Proposed modification of the Tweed Sand Quarry (Da 152-6-2005 Mod 1) with regard to the proposed increase in heavy vehicle movements

I refer to your email dated 12 April 2018 requesting Council to provide comment on the draft set of conditions for the Tweed Sand Quarry Mod 1 and traffic considerations associated with the proposed Mod. Please find below Council's comments:

Figure 2.5: Tweed Coast Road / Crescent Street Intersection Layout

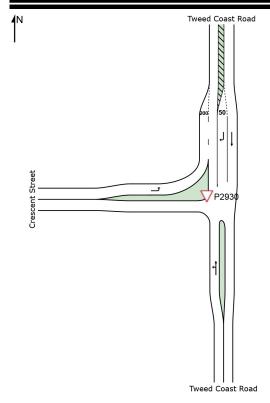
In addition, Council raises an objection to the requirement for the delayed construction of an acceleration lane on the north bound lane of Tweed Coast Road at its intersection with Crescent Street.

As previously discussed, Council has serious concerns with the upgrade being delayed until 2023 and consider that the construction should be undertaken prior to the increase in traffic volumes from the Tweed Sand Quarry.

The acceleration lane will enable heavy vehicles to merge onto the northbound traffic stream at around the posted 80km/h. The effectiveness of the upgrade to this intersection is related to the numbers of vehicles carrying out this manoeuvre and would improve the productivity of operations (as delays at the intersection would be reduced). An estimation of the cost for the treatment is in the order of \$250,000 to construct. The right turn treatment from Tweed Coast Road into Crescent Street requires changes to line marking only.

Without the north bound acceleration lane, there is the risk that heavy vehicles will enter the stream when inappropriate gaps are available leading to potential crashes and / or reduction of speeds on Tweed Coast Road, to accommodate the entering traffic. Austroads Guide to Road Design Part 4a advises that an auxiliary lane is provided for **safety and/or intersection capacity purposes**.

The Bitzios report advises that without the removal of the Crescent Street right turn movement, the Degree of Saturation at the intersection is above 0.8. Removal of the Crescent Street right turn reduces the DOS to 0.739 which is still of concern as it is approaching the 0.8 threshold which triggers an upgrade to the intersection.

As the local Roads Authority, Council previously has advised that the removal of the right turn movement from Crescent Street to Tweed Coast Road is not supported. Simply installing signs at this location banning the movement will result in non-compliance which would need to be addressed by Police. Installing physical devices to prohibit the movement would result in construction costs borne by Council, which is unacceptable.

Accordingly, it is considered appropriate that Condition 24 be modified such that any final agreement between Tweed Sand Quarry and Cudgen Lakes Sand Quarry (arranged prior to determination) be referenced in the condition and that the timing of the upgrade to the intersection of Tweed Coast Road and Crescent Street (i.e. constructing a northbound acceleration lane on Tweed Coast Road to the appropriate Austroads requirements) be prior to any increase in truck movements associated with Mod 1.
